I've just taken a look at the above planning application and it appears there is insufficient information in order for me to make formal comment at this stage. My reasons are as follows:

SCALE / 1:100 @ A3
DATE / 22.03.2017
DWG. NO / 080616 / TP.02 'A'

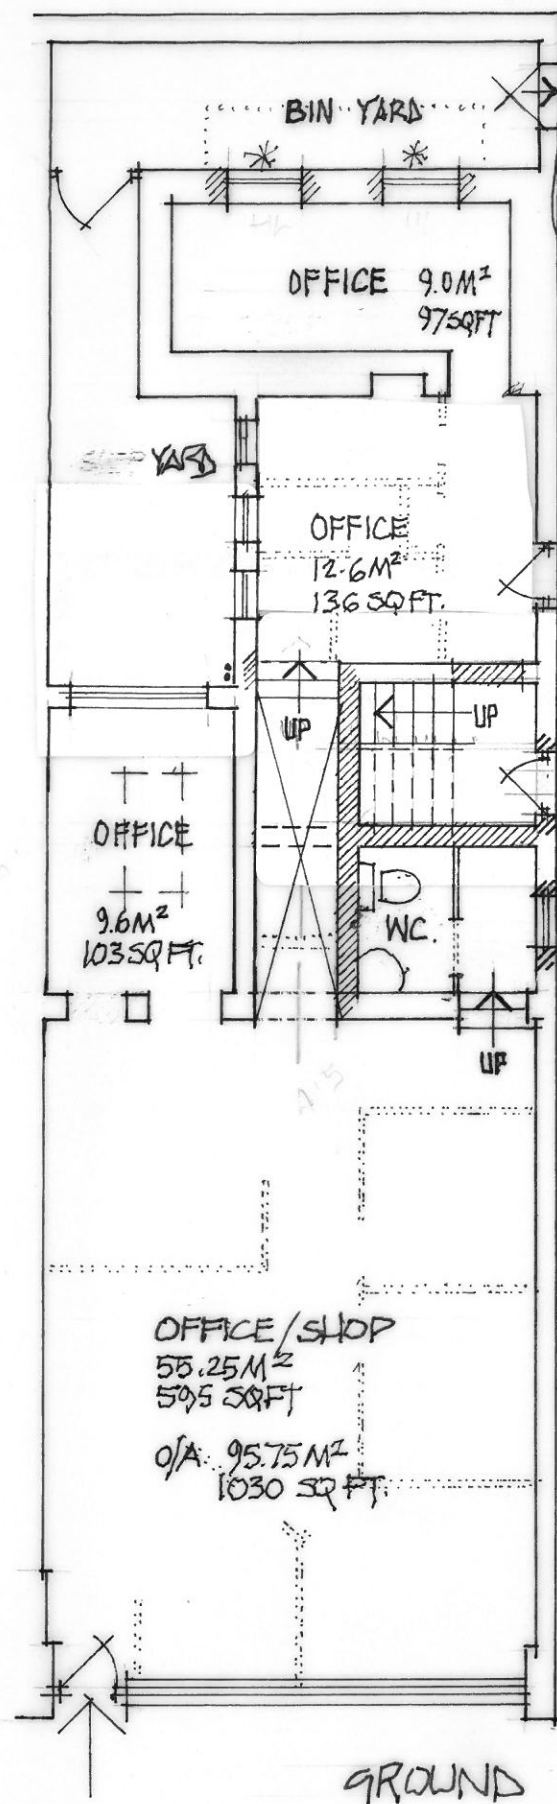
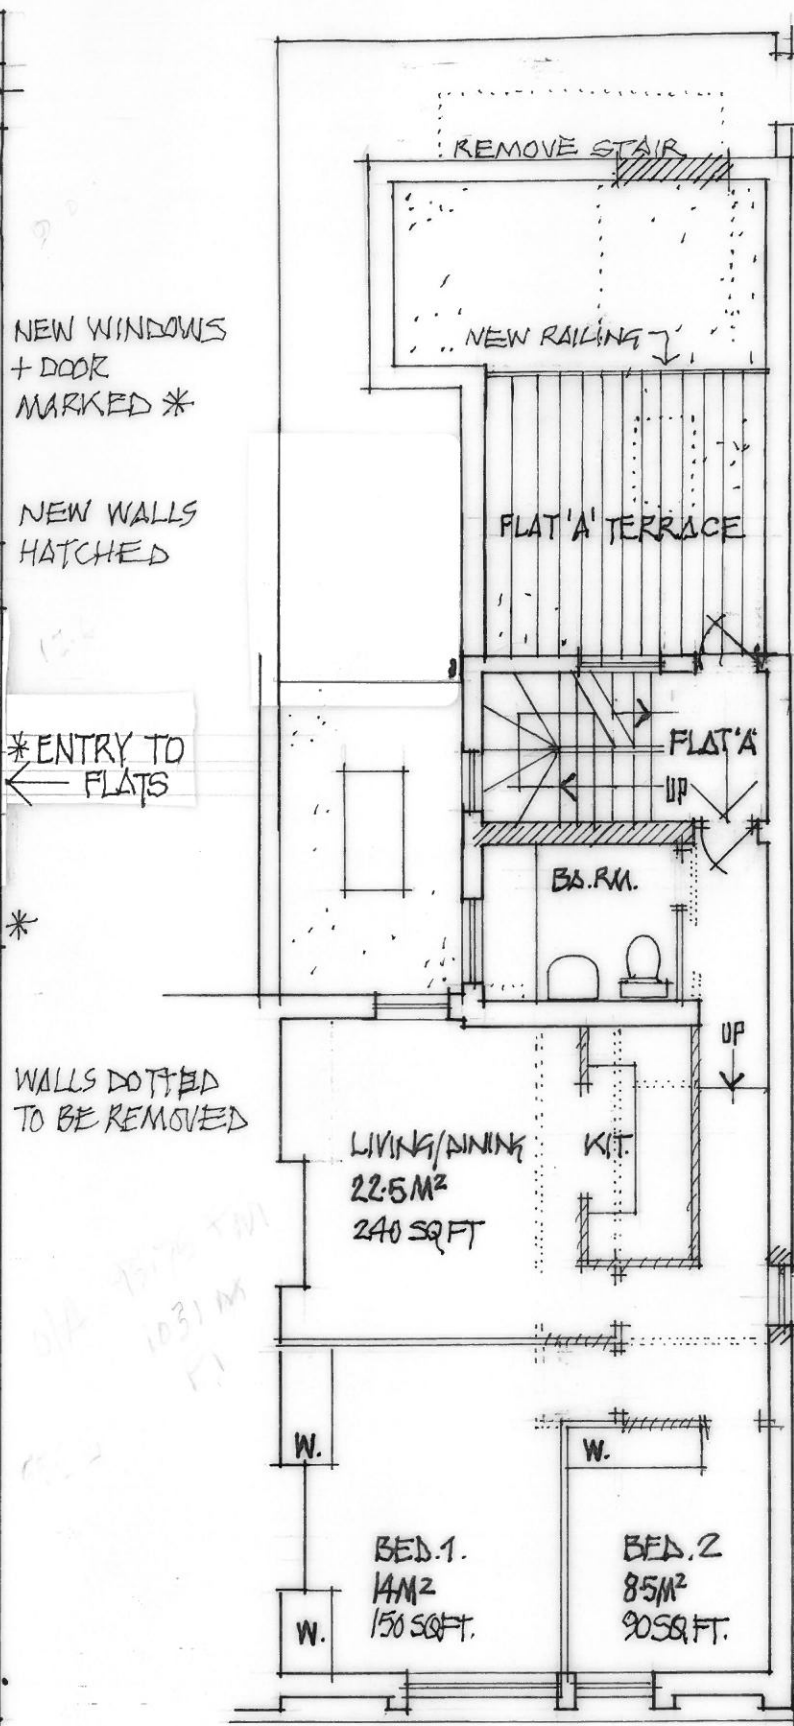
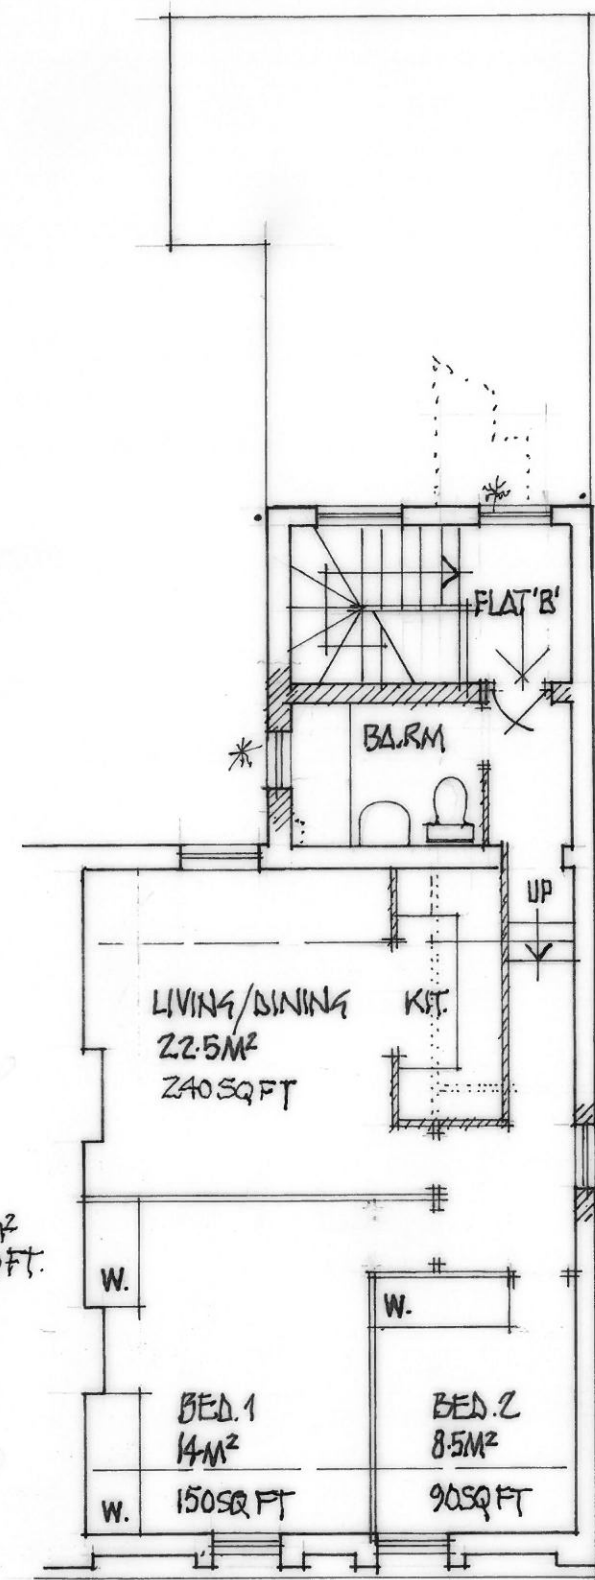
- 1) There are areas on the first and second floors where the letter "W" is written. What does this mean? Wall?
- 2) The applicant has proposed to site the entrance door to the internal communal staircase, located at ground floor level in the entrance road to Manor Car Park. The road itself is rather narrow and to have a residential doorway opening onto it would seem unsafe without a paved/guarded area to exit/enter onto to. My thoughts are that perhaps keeping the external stairs would be a safer option, but I appreciate Flat A wouldn't then have exclusive access to the roof terrace.

- 3) There is no mention of a fire alarm system and what fire-resisting separation there is between the commercial and domestic areas.
- 4) Internal doors are not annotated on the plans supplied for the flats.

DWG.NE/080616/TPO3A'

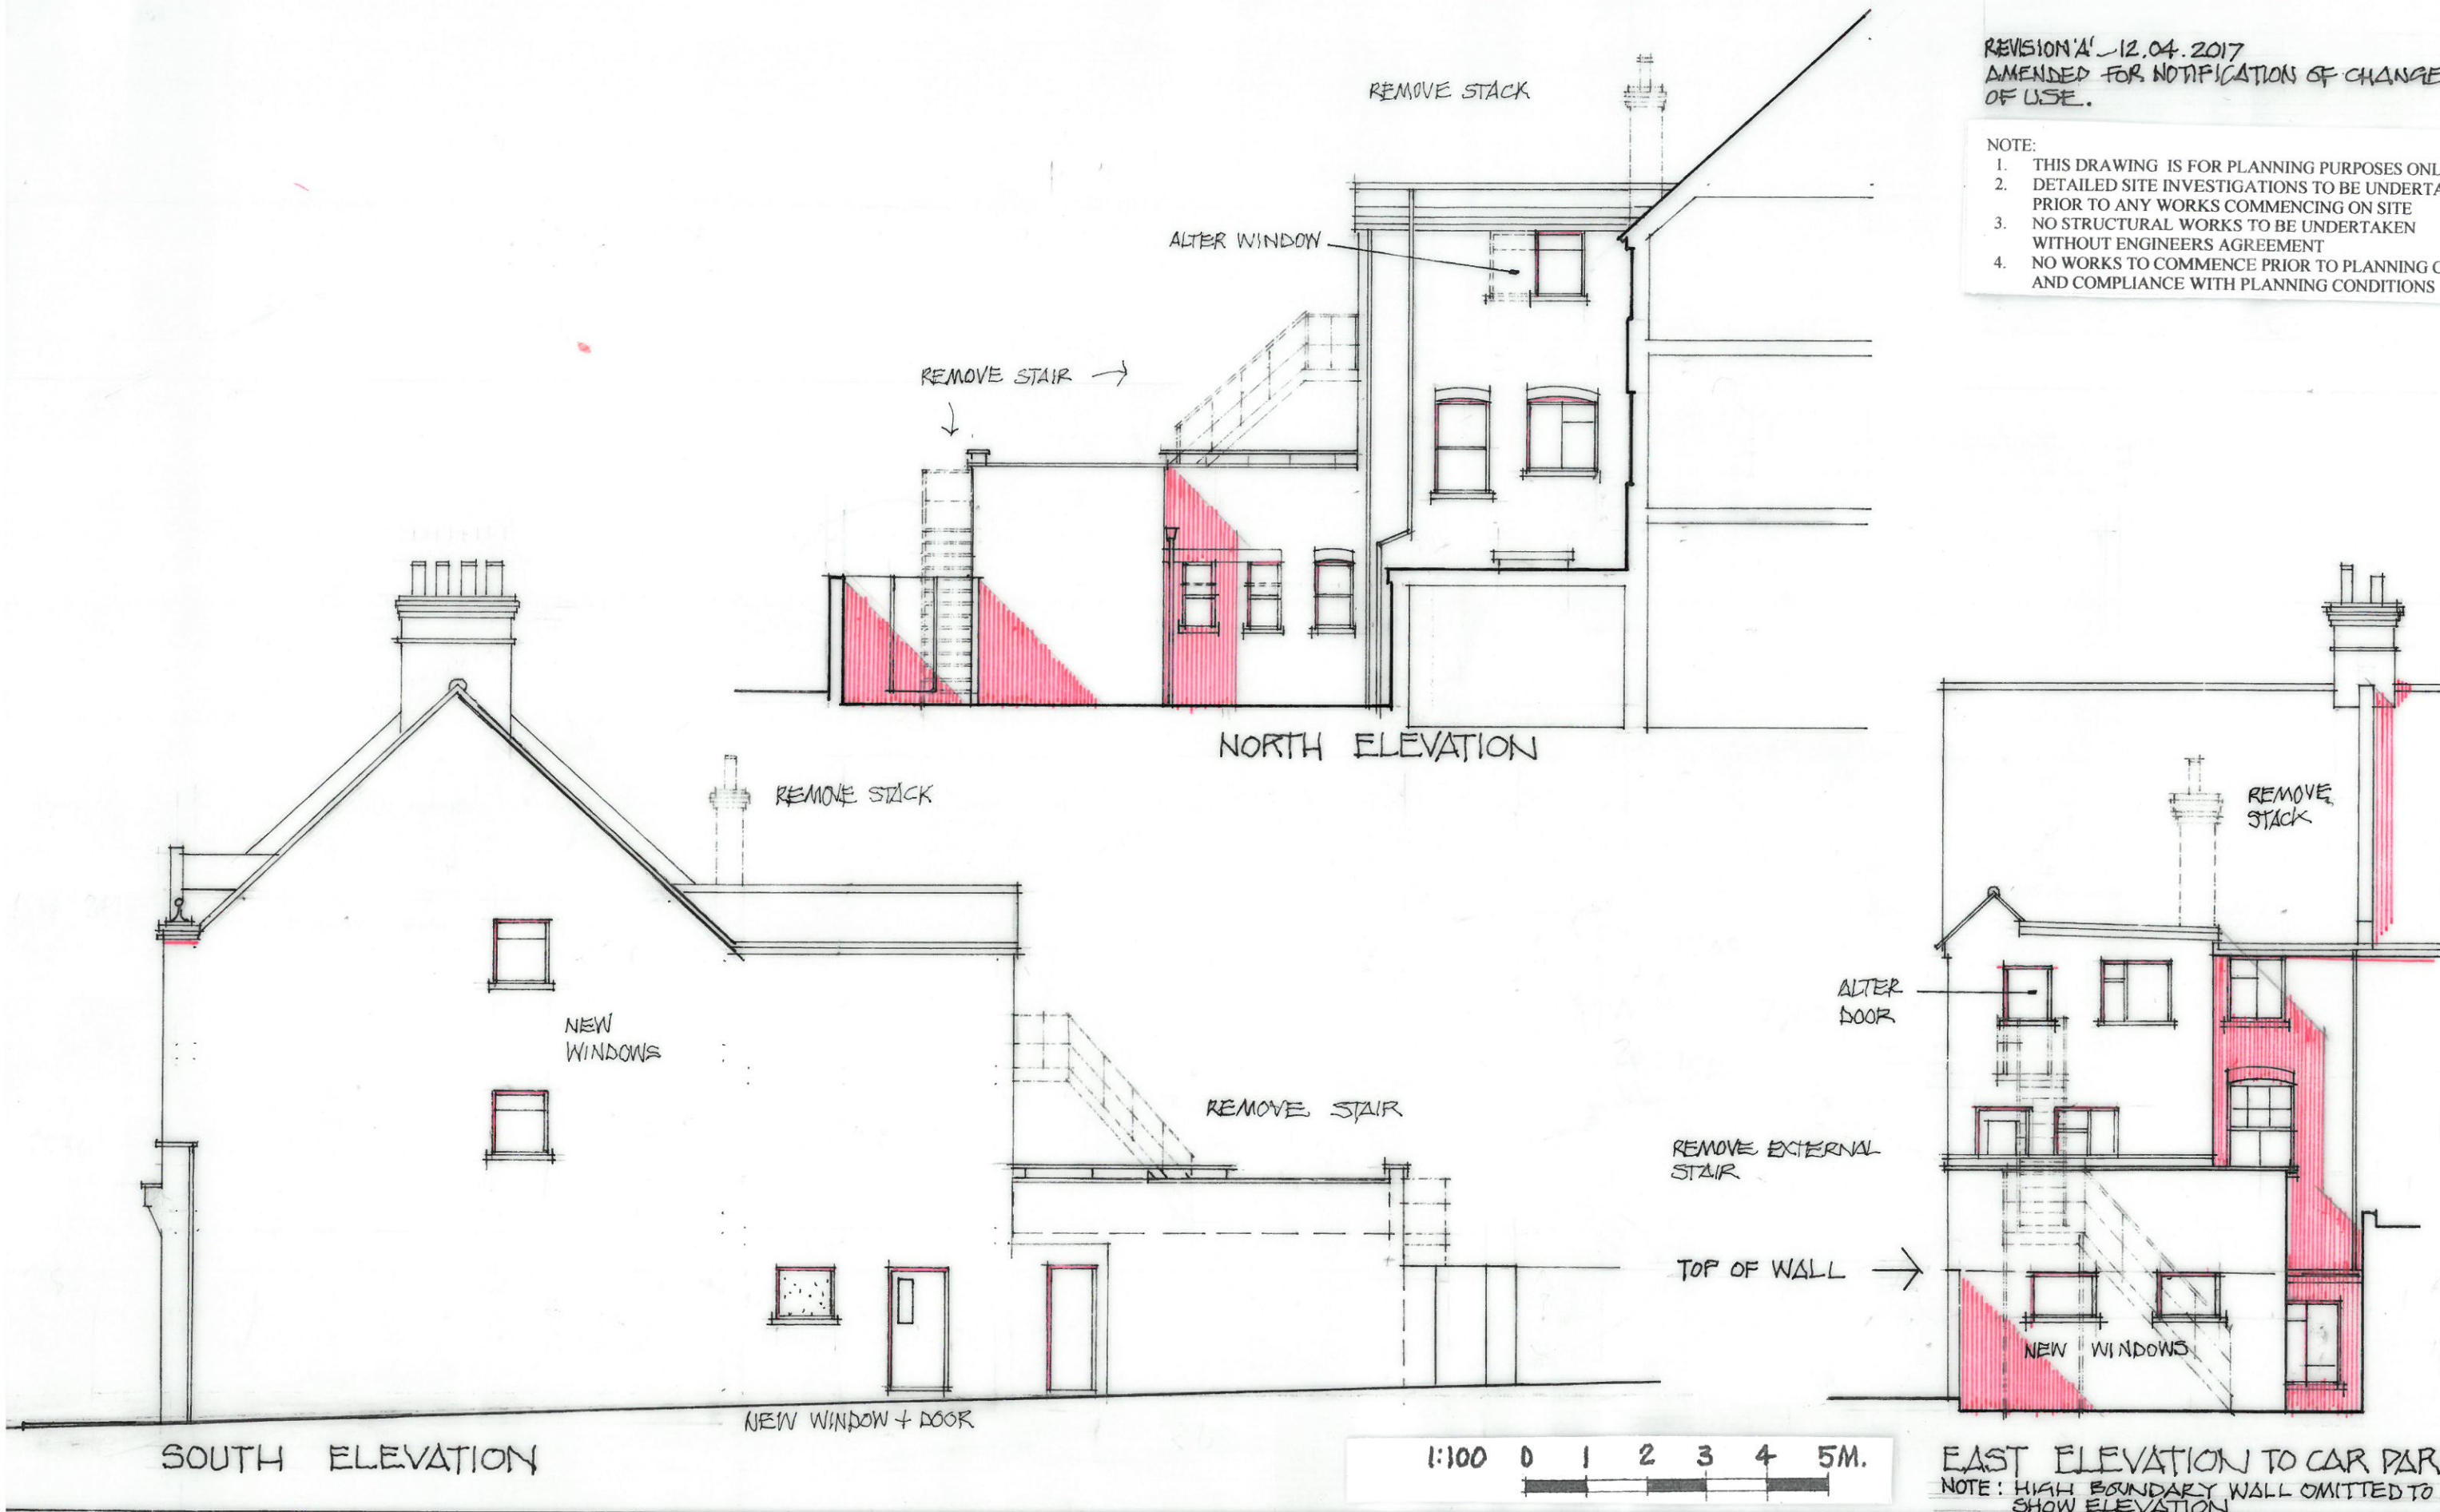
- 5) Railings to the Flat A roof terrace have been proposed, but no detail of height and type have been provided.
